3D Community
Church

Re: Plan Reviews Re Submittal

We have updated and revised the following Drawing Sheets in response to Plan Review Notes dated 6/30/2022: Revisions One dated 07 05 2022

LIFE SAFETY PLAN

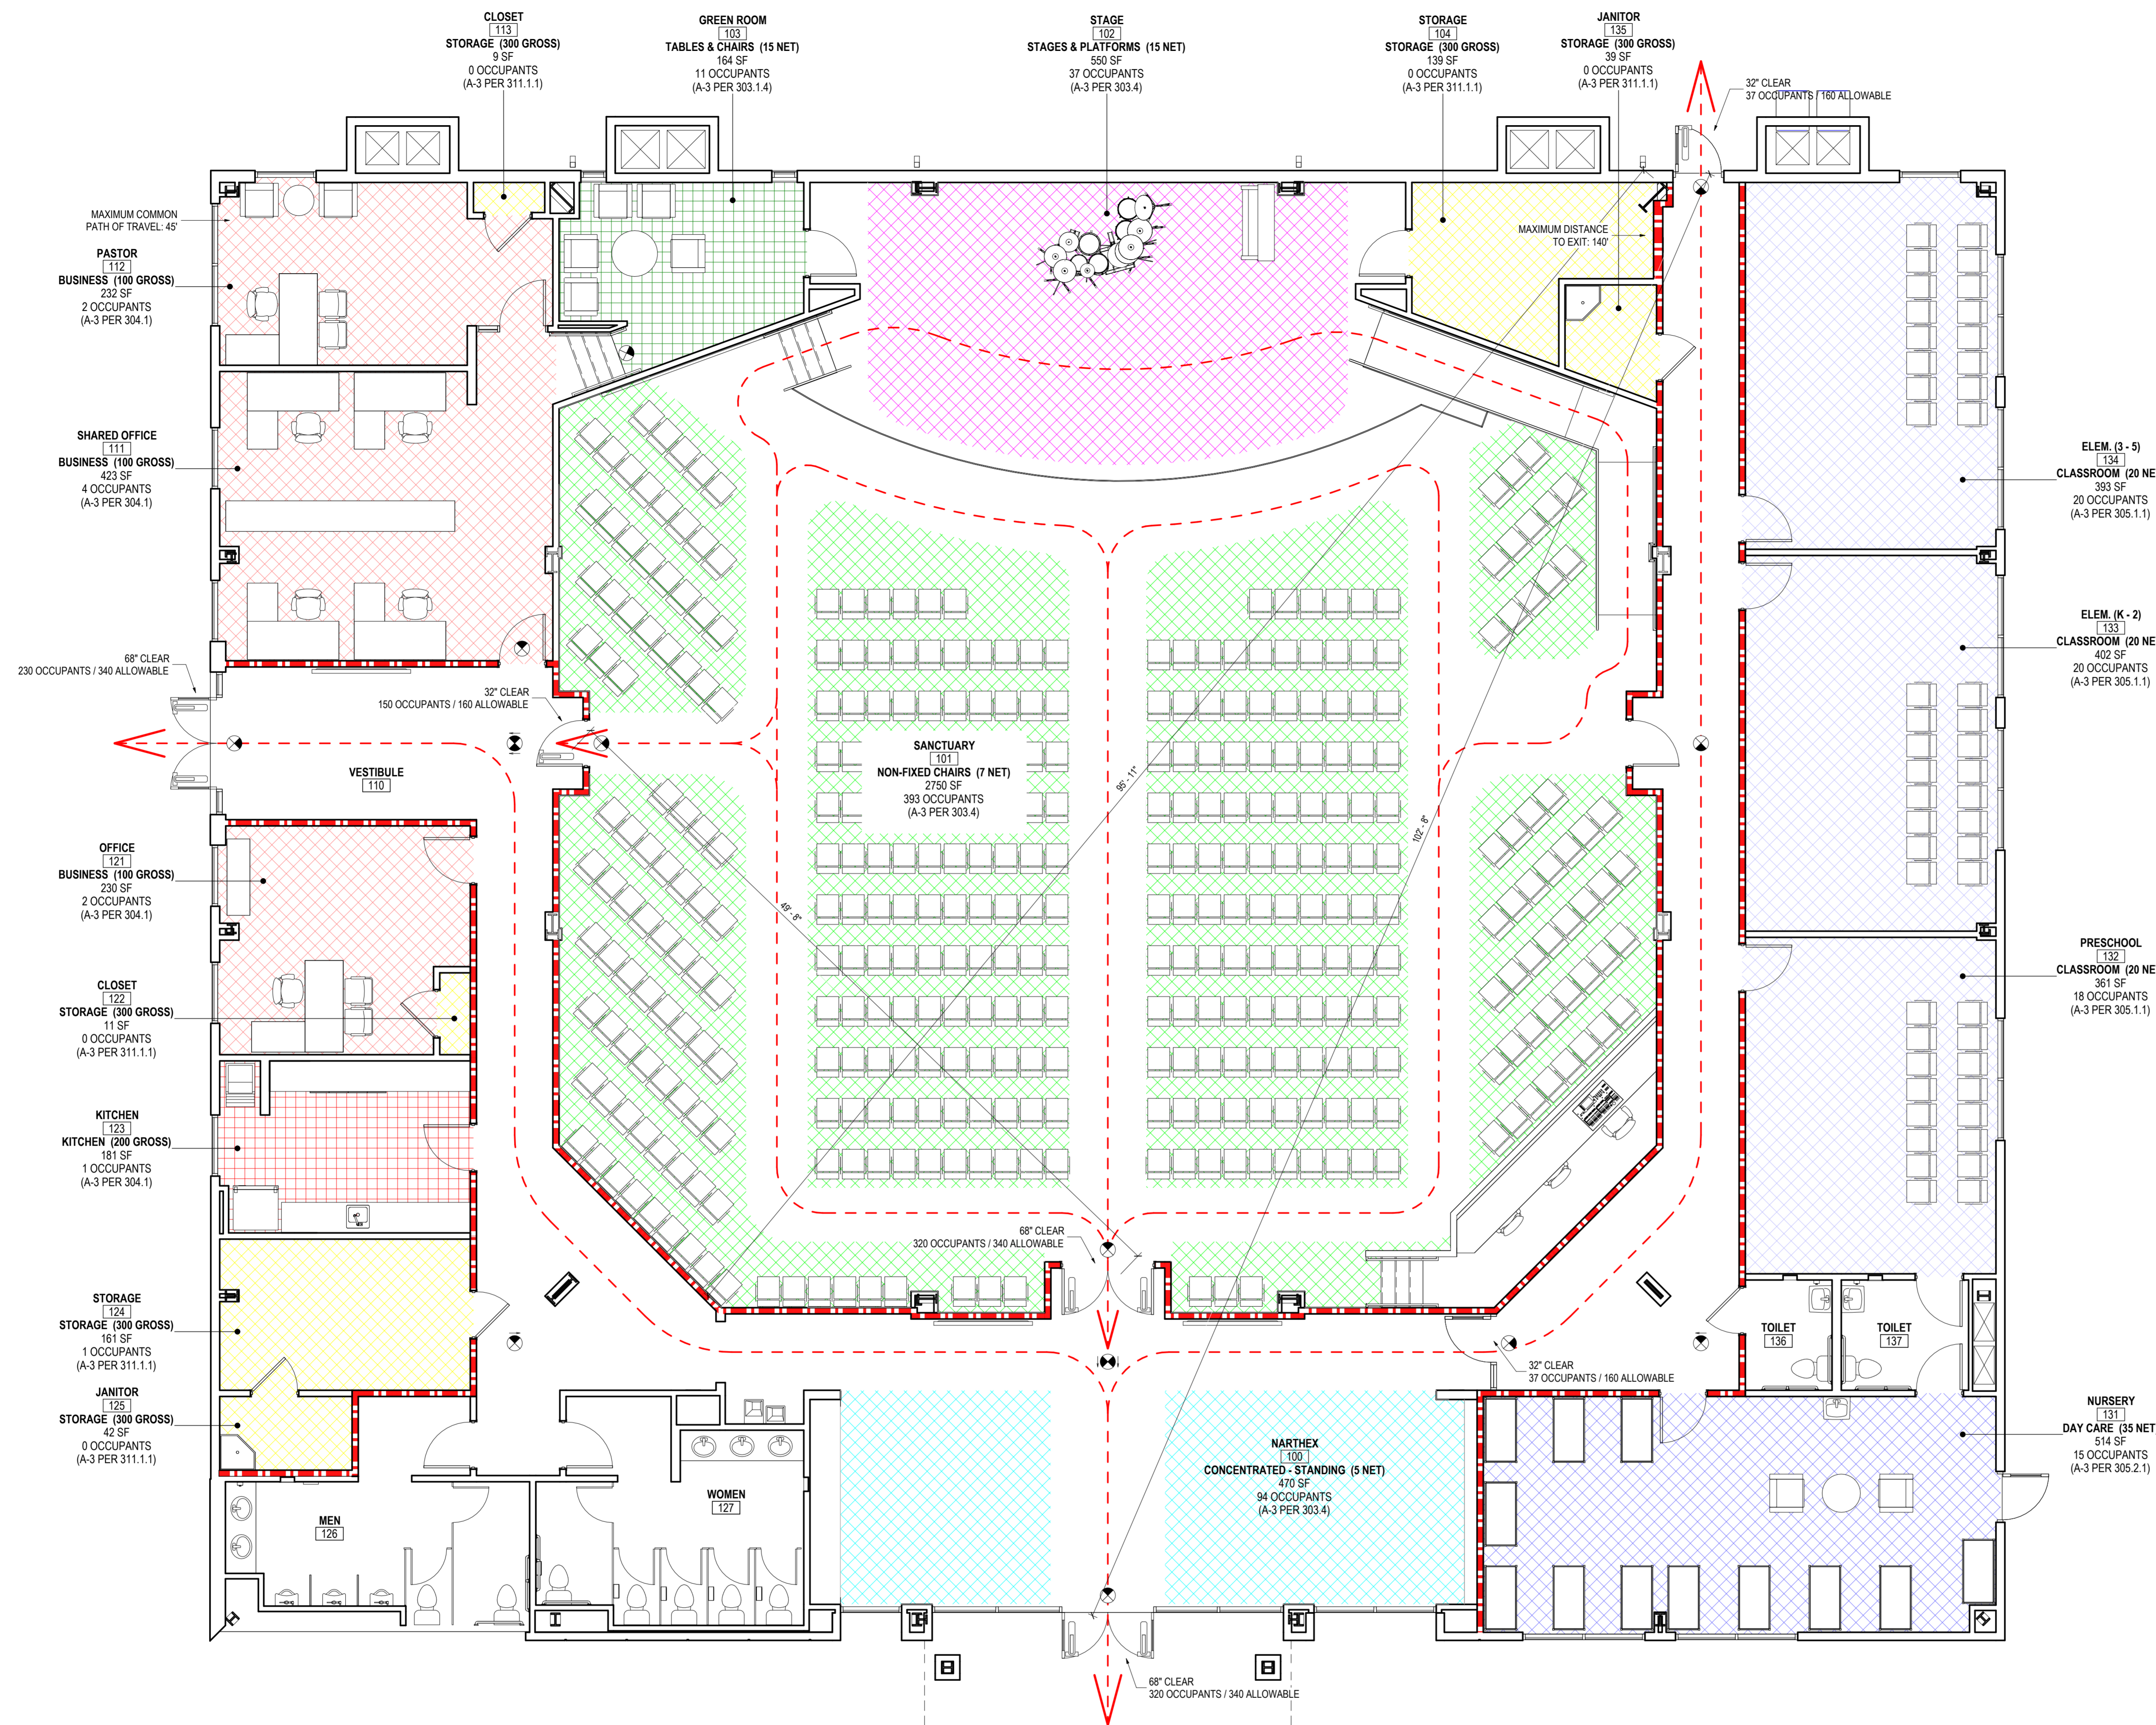
6.- A-8 Life Safety Floor Plans Occupant Contents to 525. Deleted Classroom 126.
